RE: DRAINAGE PLAN FOR THE PET DOCTOR (C-12/D3B2) ENGINEER'S STAMP DATED APRIL 2, 1992

Based on the information provided on your April 2, 1992 resubmittal, the above referenced site is approved for Building Permit. Please be advised that prior to Certificate of Occupancy release Engineer Certification per the D.P.M. checklist will be required.

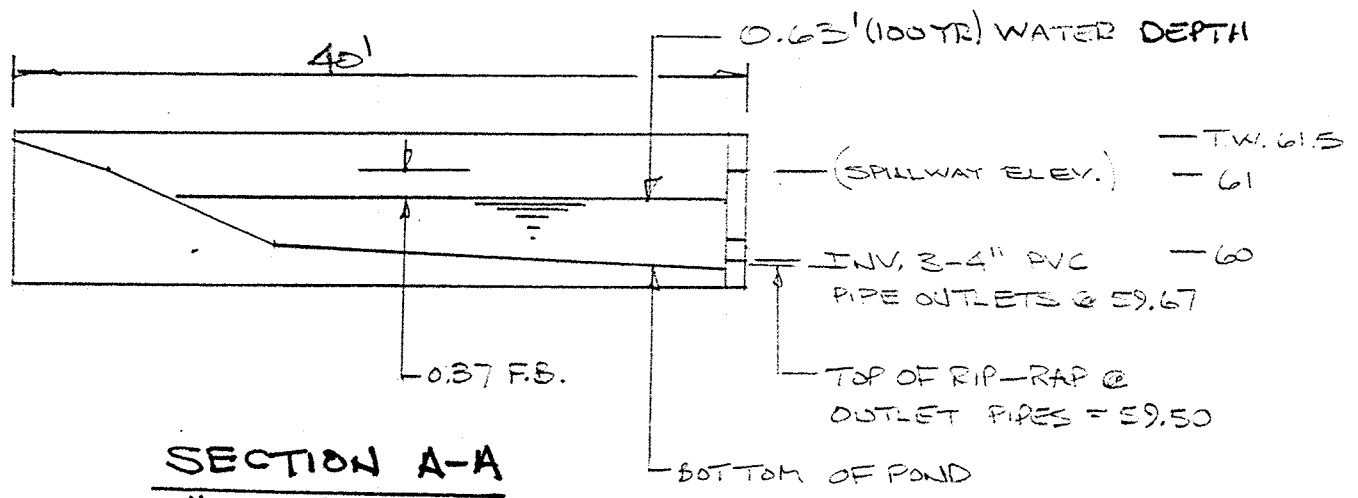
2. TYPICAL POND SECTIONS INCLUDES SPOT ELEVATIONS AND THE 100 YR. WATER SURFACE ELEVATION.
 (SEE ATTACHED DRAWING)
